" The Shades "
616 Euchareena Road
Molong NSW 2866
30th May 2012

ATTENTION: Mr. Chris Ritchie And Mr. Andrew Hartcher
RE: PROPOSED MODIFICATIONS – ORANGE WASTE PROJECT (09_0025 MOD 1)

Figure 5: Approved and proposed ERRRC site dam and composting area comparison

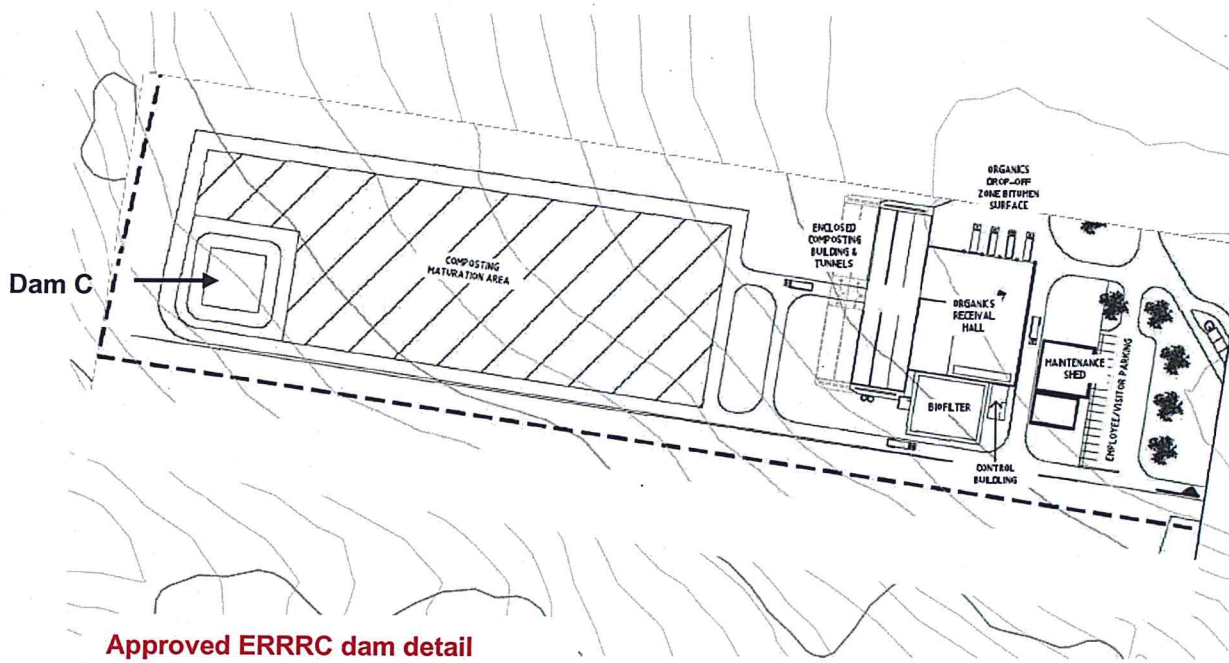
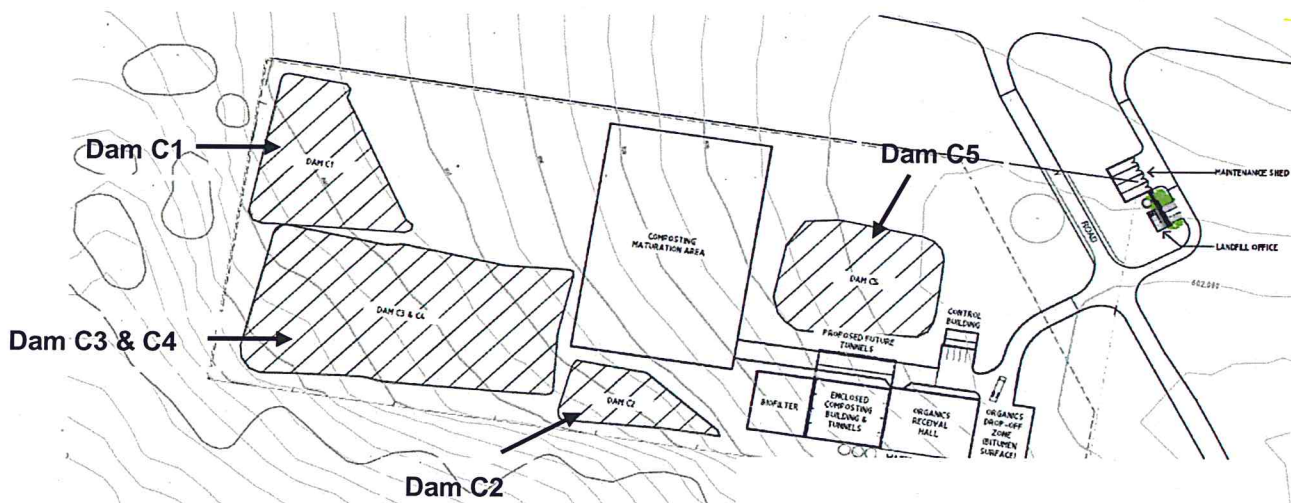
In our previous submission we drew your attention to the fact that the dams were no longer shown on the approved layout plans. The response says that Dam A and Dam B remain but " Dam C has now been split to form 5 smaller dams." We are also told that "The dam function has not changed" , but we note that the storage capacity for the 5 smaller dams has increased enormously to 10ML. Appendix J Surface Water Assessment for the E.A. stated that the capacity of Dam C was only 0.5ML. Surely this is a major and not minor modification, as indicated by the proponent, and is very deceiving.

We are on the down hill side of this project both to the West and the East and any change to water movements effect us greatly.
